RE: 8 Arlington Street – 126-F-008 – R-3 Residential Zone – Permit #09-0817

I am in receipt of your application to expand the existing 6' x 17' 1 story laundry room to 12' x 17' and to add 12' x 20' deck and steps at the rear of the existing house. Your permit is denied because it can not meet the requirements of the Land Use Zoning Ordinance.

DENNEY addition + STAIRS 7-30-09  
 Floor and rear yard plow  $\frac{1}{8}$ " = 10"

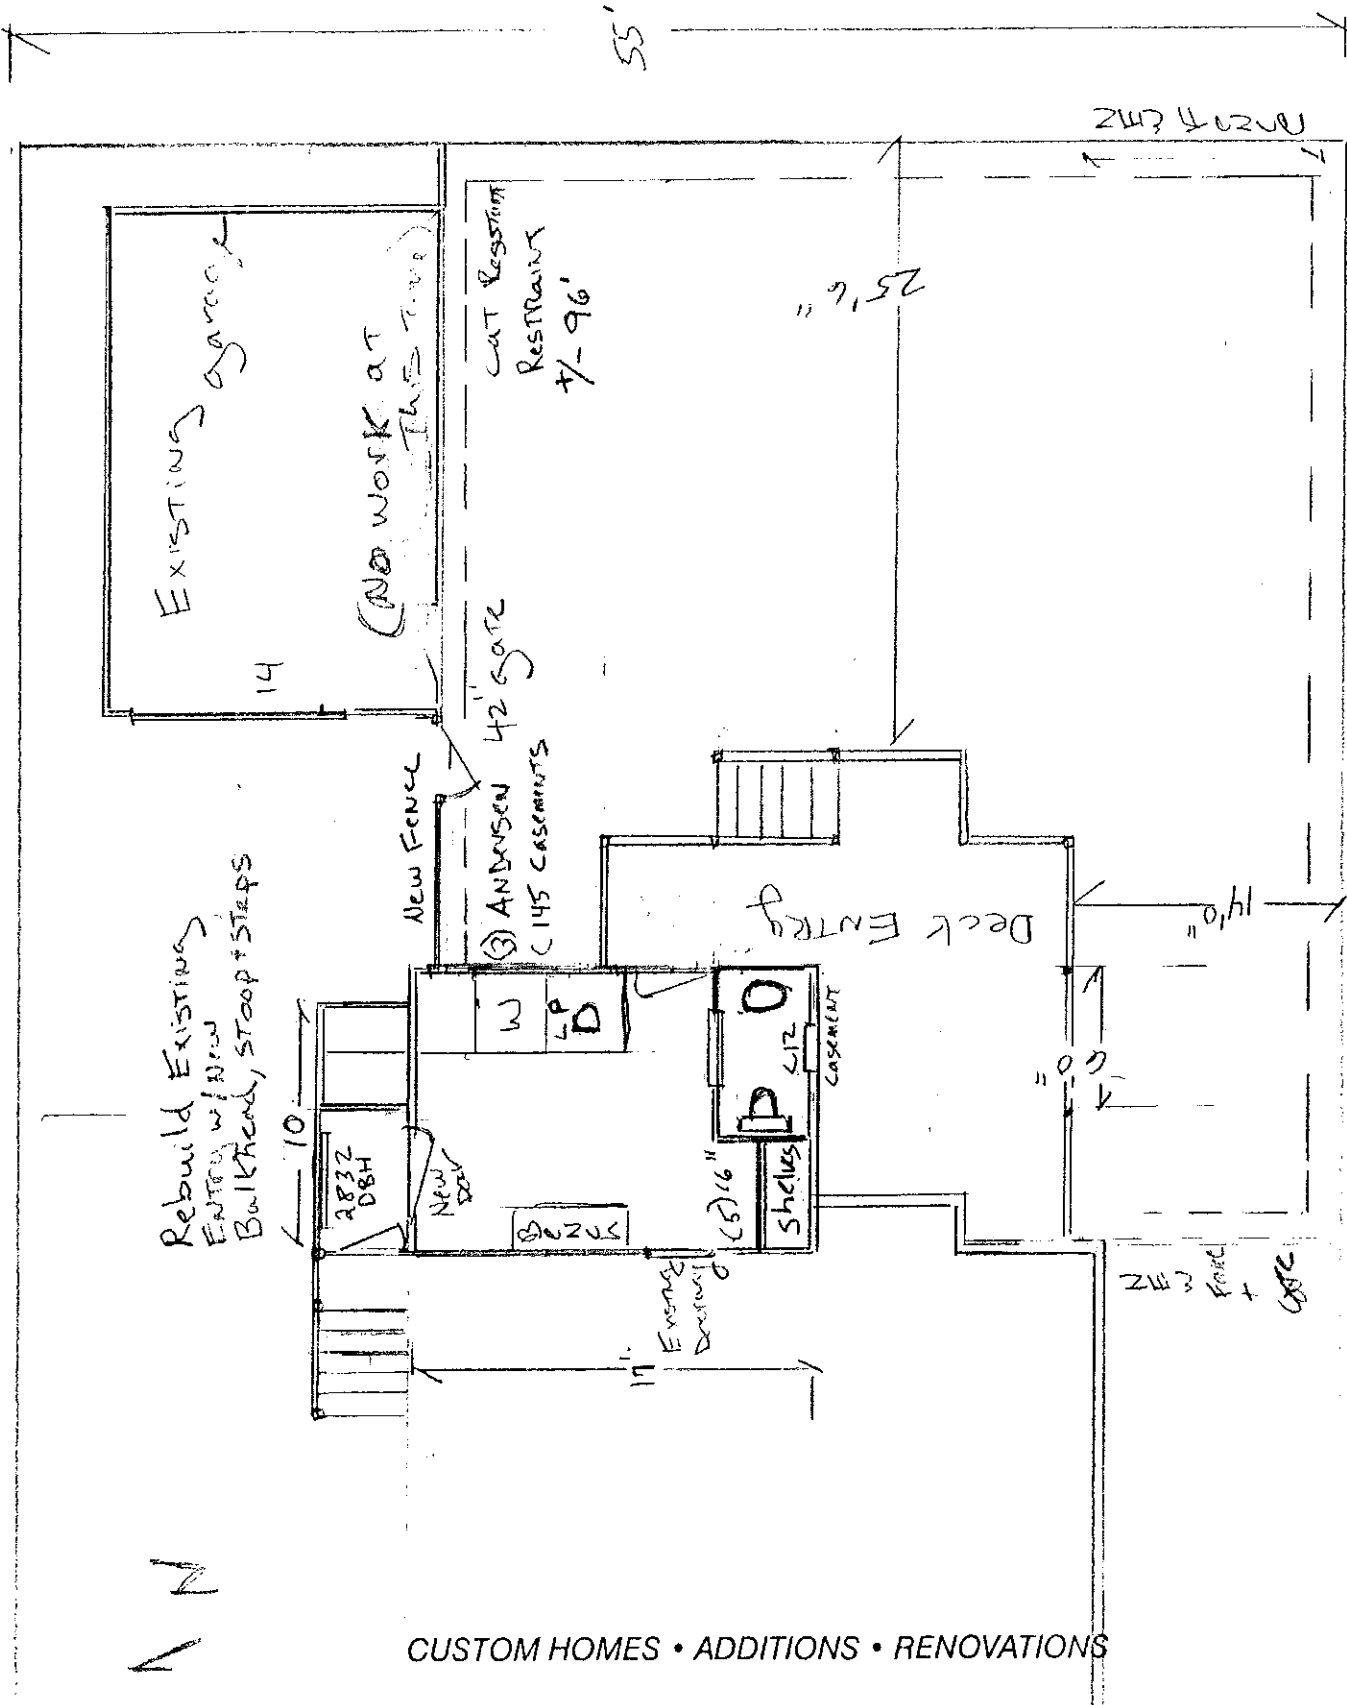
Also the R-3 Zone requires a minimum rear setback of 25 feet under section 14- 90(d)2 instead of the 21 feet shown on your plan submittal. Your permit is also denied because the proposal does not meet the R-3 Zone rear setback.
